**Major Project Application 07\_0004 Modification No 2**

**SUBMISSION TO THE NSW DEPARTMENT OF PLANNING  
FOR A MAJOR PROJECT TO BE DETERMINED UNDER PART 3A OF THE  
ENVIRONMENTAL PLANNING & ASSESSMENT ACT, 1979**

**MAJOR PROJECT APPLICATION No. 07\_0004  
MODIFICATION No 2**

**PROPOSAL:** Huskisson Hotel redevelopment including  
refurbishment of the existing hotel building, function  
room, day spa, 38 hotel rooms, 14 apartments,  
swimming pool, bistro, restaurant and car parking.

**PROPOSED ADDITIONS AND
ALTERATIONS :-
GROUND FLOOR PLAN**

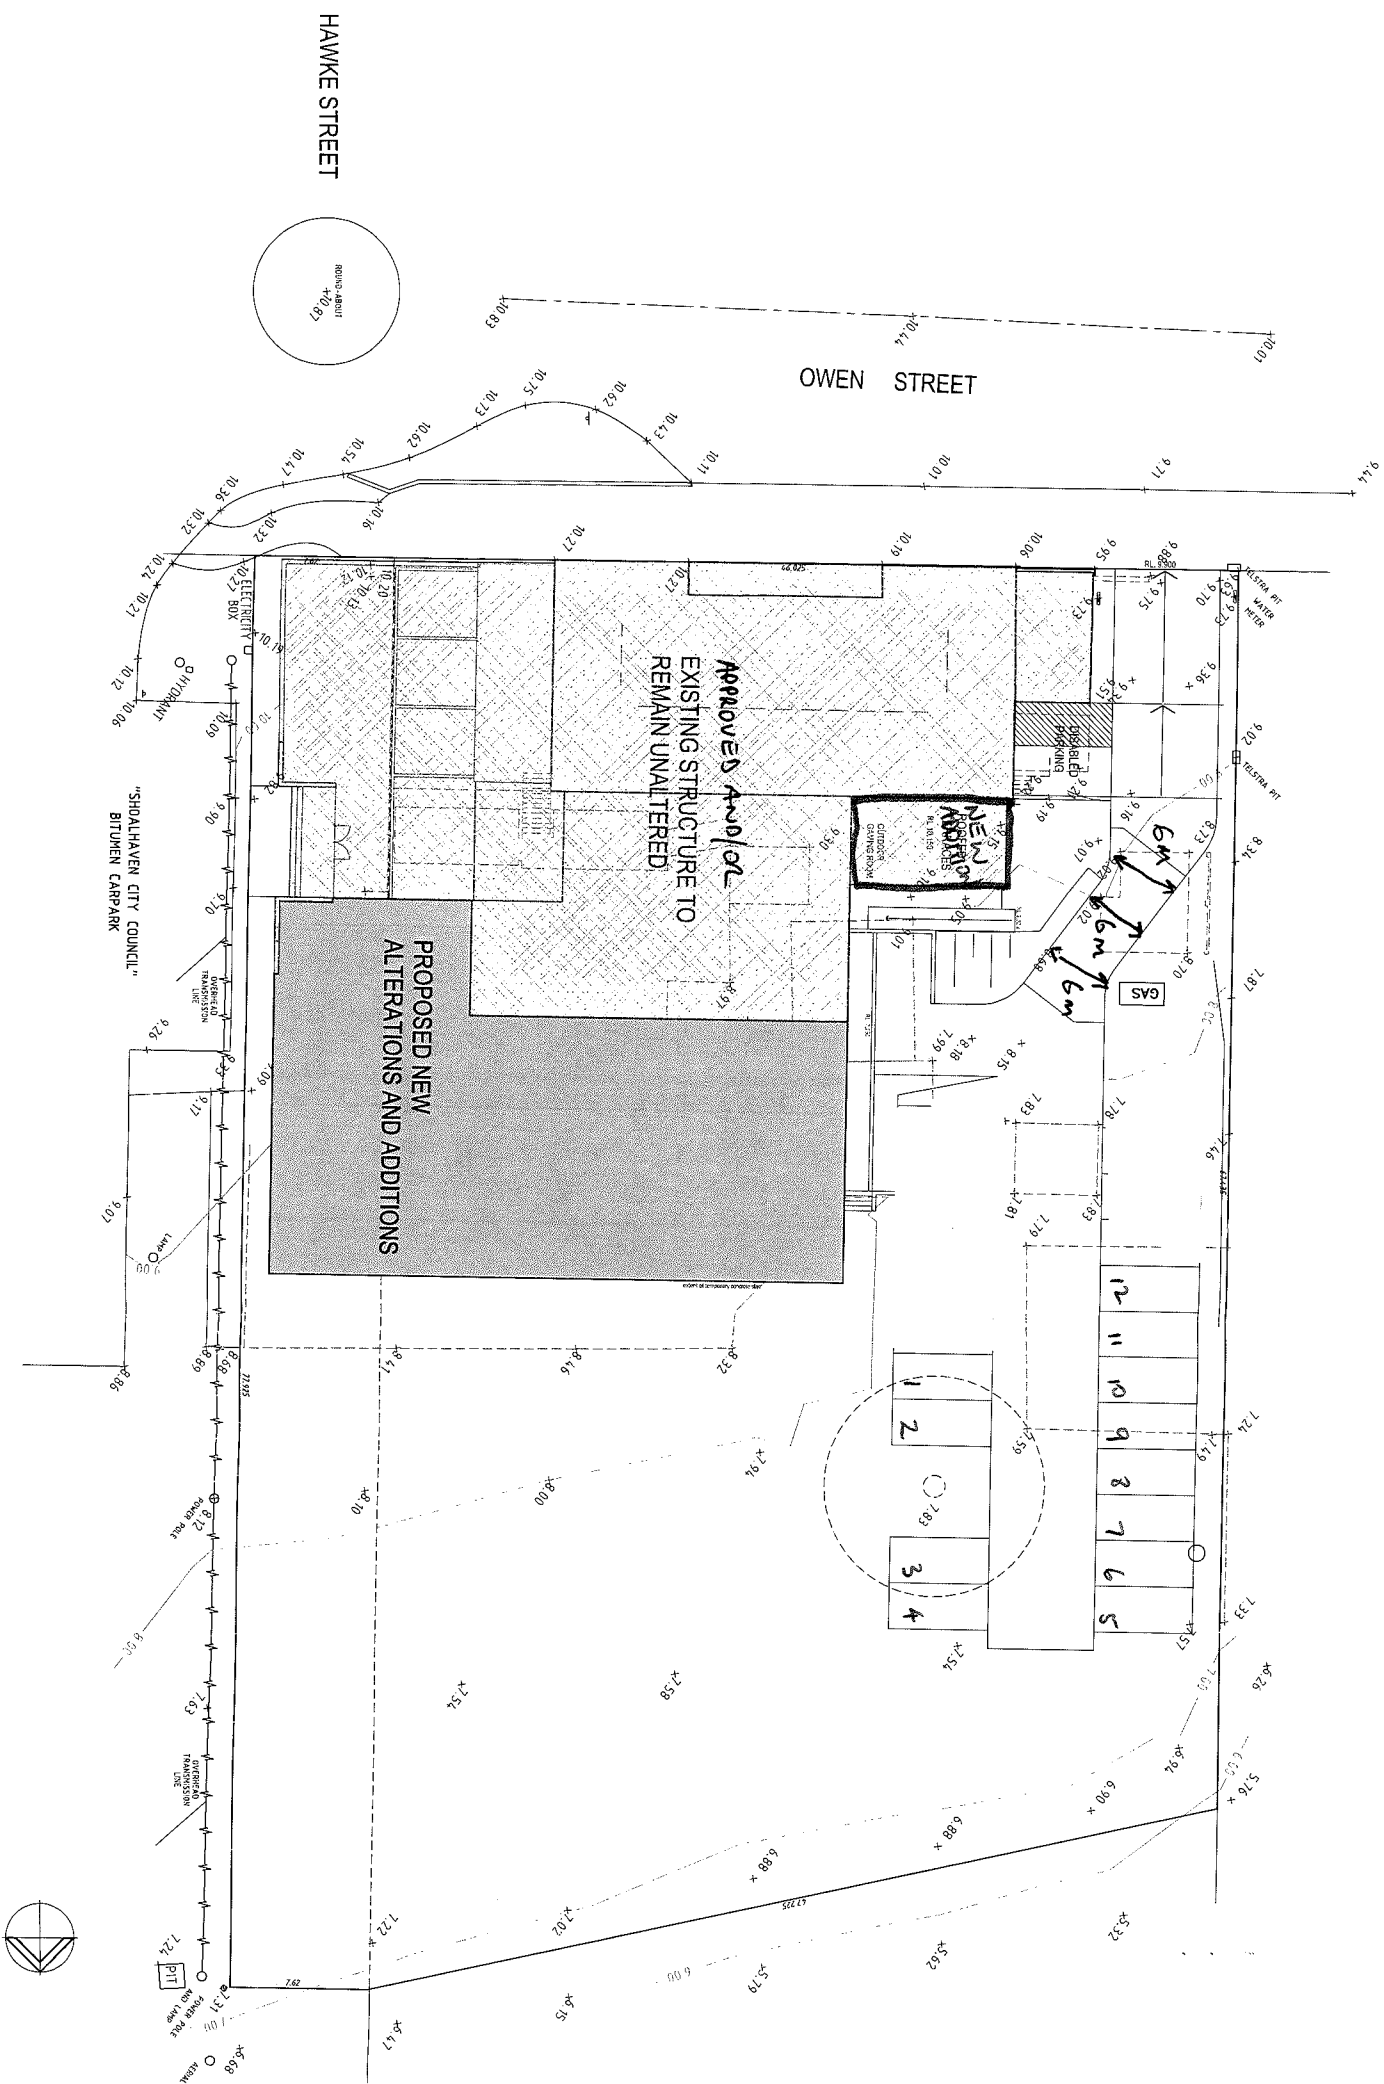
- (a) The proposed modification (A2) relates to Project approval (12 Oct 2010) condition numbering however for the MOD 1 approval (12 Aug 2011) the same condition is numbered as A1.
- (b) In respect of the proposed MOD 2 for Stage 1 (d) the public bar terrace, function room and adjacent terrace will be demolished when stage 2 takes place (not Stage 3) based on the MOD 1 approved plans. The floor area of the MOD 1 Function Room will be absorbed in part by the Stage 2 hotel reception area (plan 11-04 )
- (c) The proponent 's modification justification refers to issues that the proposed modification Stage 1 (d) does not include ie, the additional bistro terrace. Council's submission 3.2, below, addresses the issues arising for the extensive ground floor terraces shown on additional plan ( Plan No 102/01) .

**(c) Additional Bistro Terrace:** The “additional bistro terrace” has an area of approximately 260 m<sup>2</sup> and is adjoining the MOD 1 approved 212m<sup>2</sup> outdoor terraces, making a total capacity for use as outdoor bistro / beer garden area of 472m<sup>2</sup>. The existing outdoor beer garden is 354 m<sup>2</sup> and this has been demolished in preparation of the stage 1 work.

The proponent’s justification shown on submitted drawings Appendix 1/A and 1/B) is that the new indoor areas and the new outdoor areas are equivalent of the existing indoor / outdoor areas they are replacing. Council does not oppose the proposal.

STAGE 1: HUSKISSON HOTEL LANDSCAPE DA PLAN

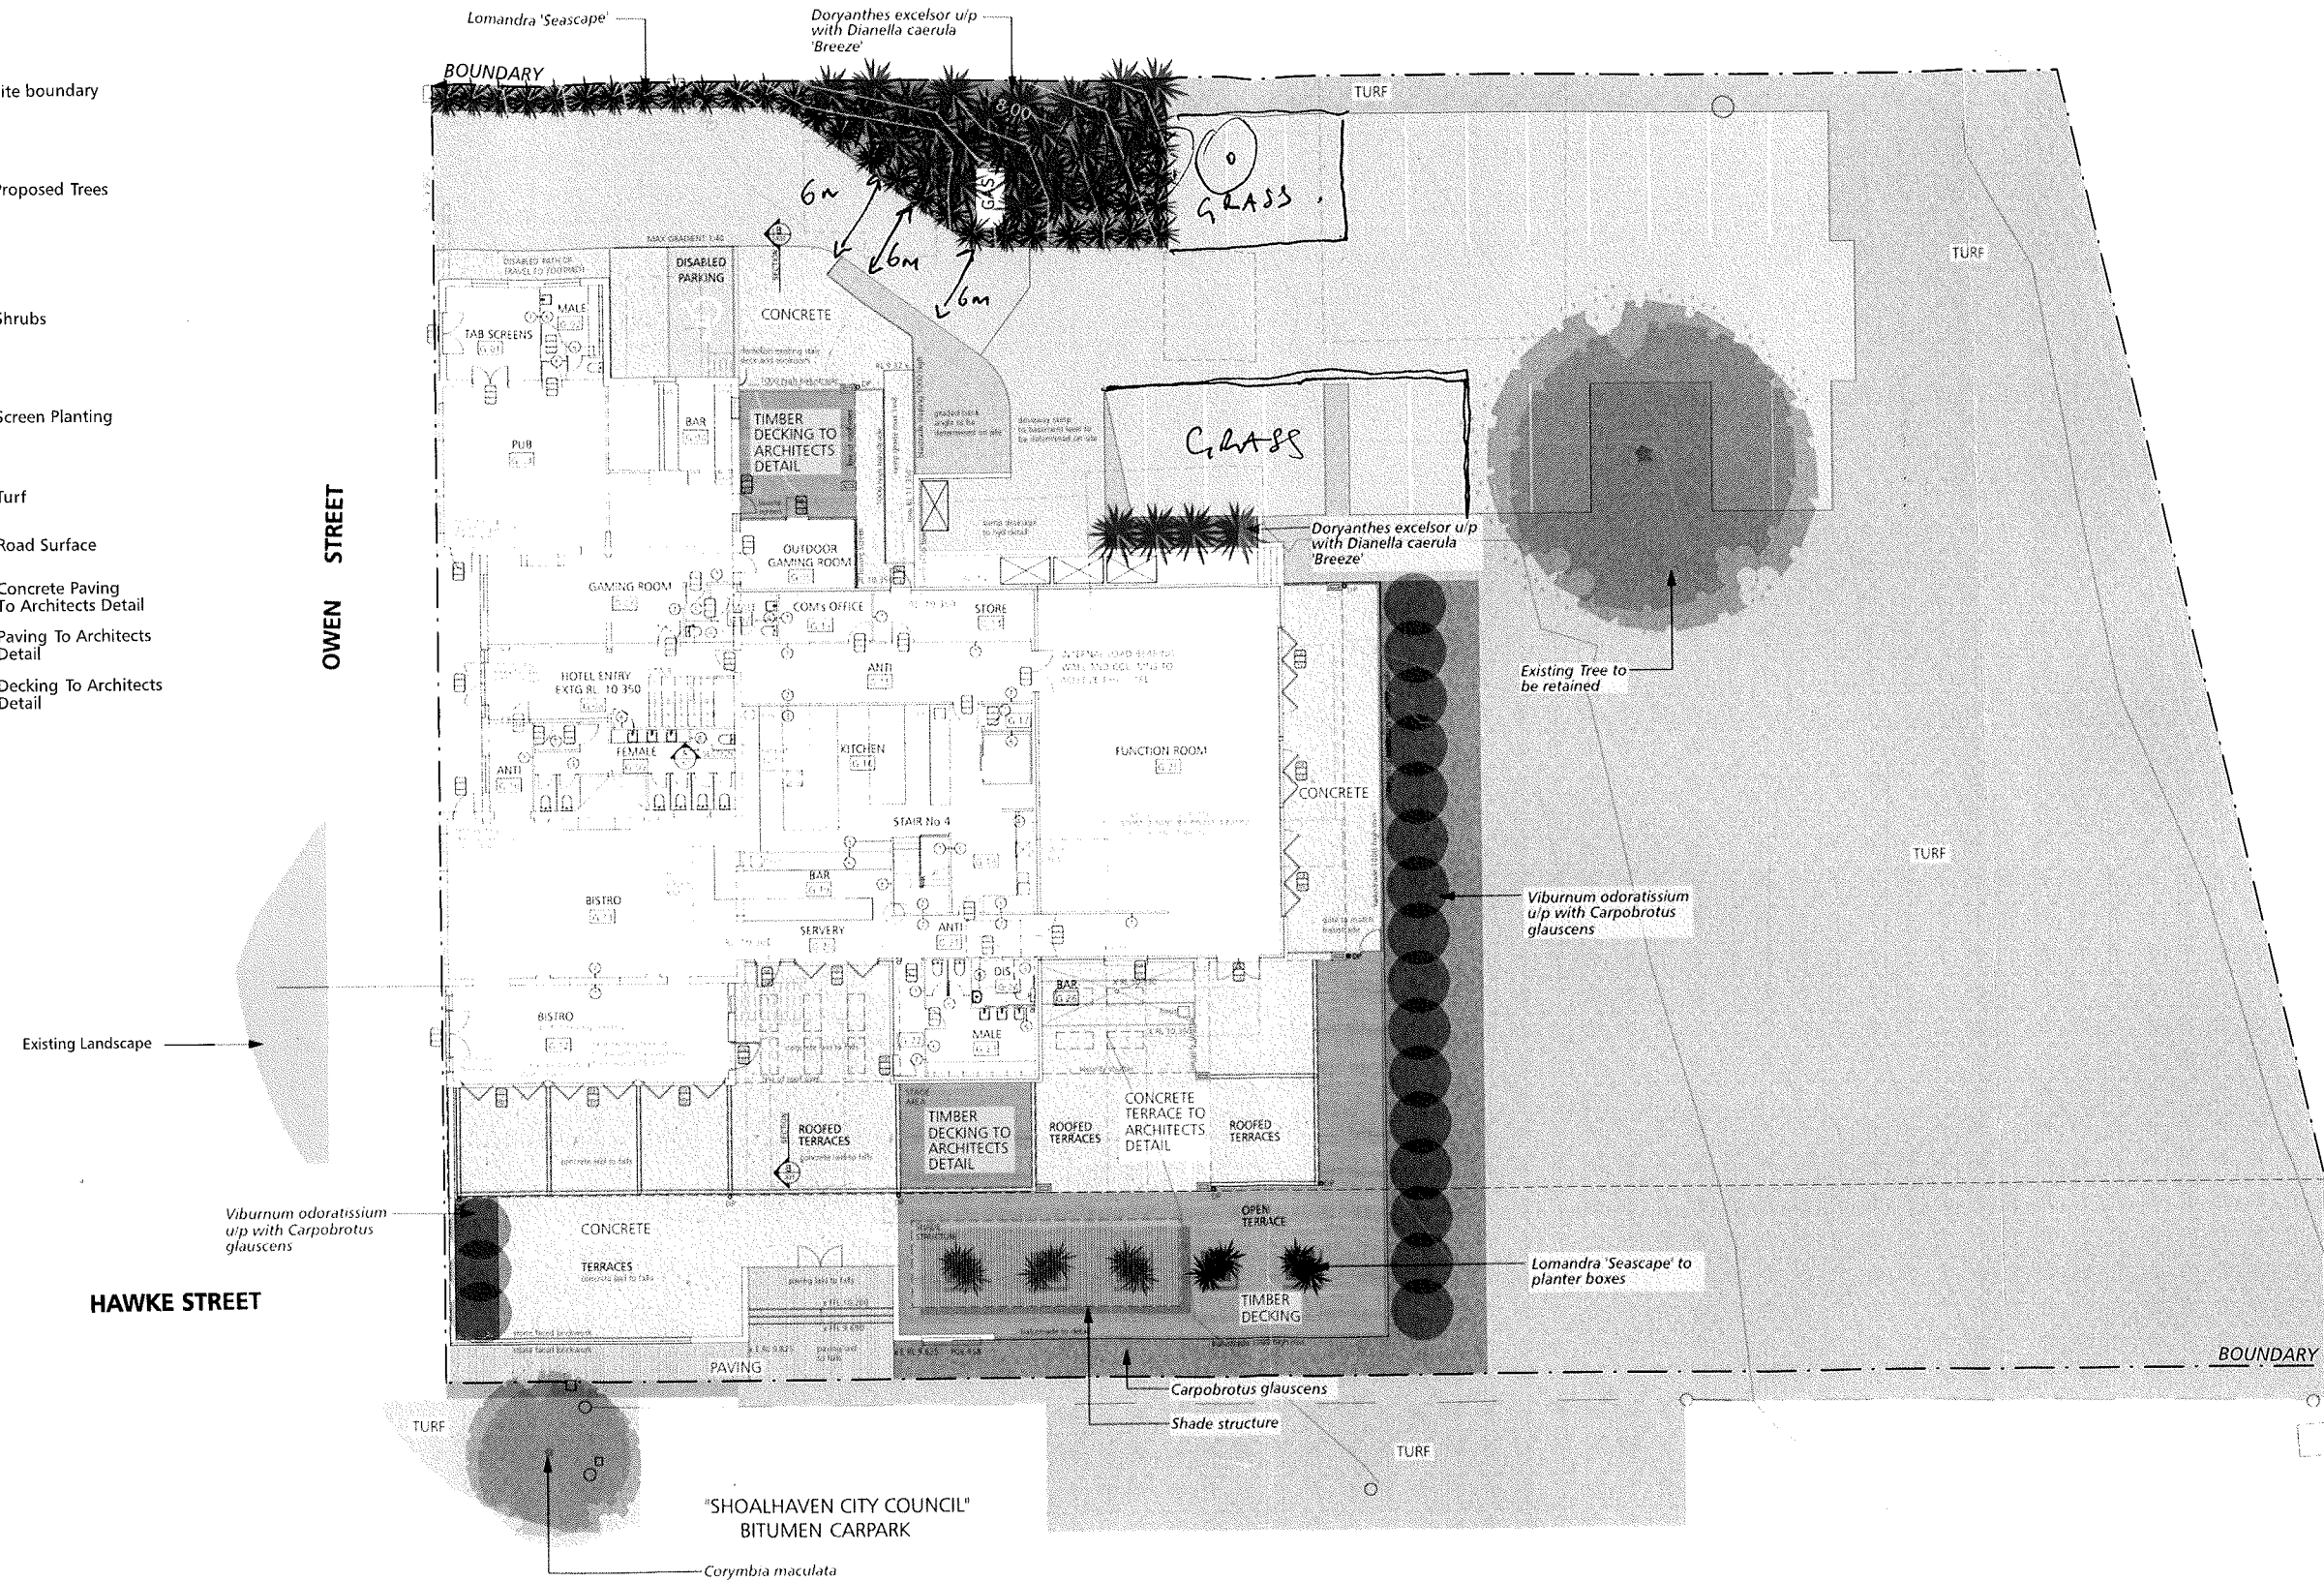
The proponent's MOD 2 application includes an amended Landscape Plan by Spacman Mossop (drawing number LP001) and an additional copy of that plan includes some handwritten notations by the proponent in respect of the width of the driveway. The latter plan is exhibited as "Additional Plans" on the Department's website. The proponent has advised Council separately that the existing gas container is to be relocated.

The details of landscaping species have been discussed with the proponent and further advice will be provided by the proponent following determination of MOD 2. There are complementary civil engineering plans regarding construction standards required for the car park area and driveways. A civil plan for car parking including corrected driveway width (Sellick C303) is part of MOD 2 additional plans and is referred to in 3.3, below.

However, since the proponent's intent to satisfy the condition is a Landscape Plan that included handwritten notations for the driveway width and other detail, the condition wording that requires the submission of a landscape plan should remain so a final and acceptable plan can form part of the approval documents.

Council supports the modification of approved condition B20 to delete "Stage 2" and insert words "for Stage 1 and each subsequent stage".
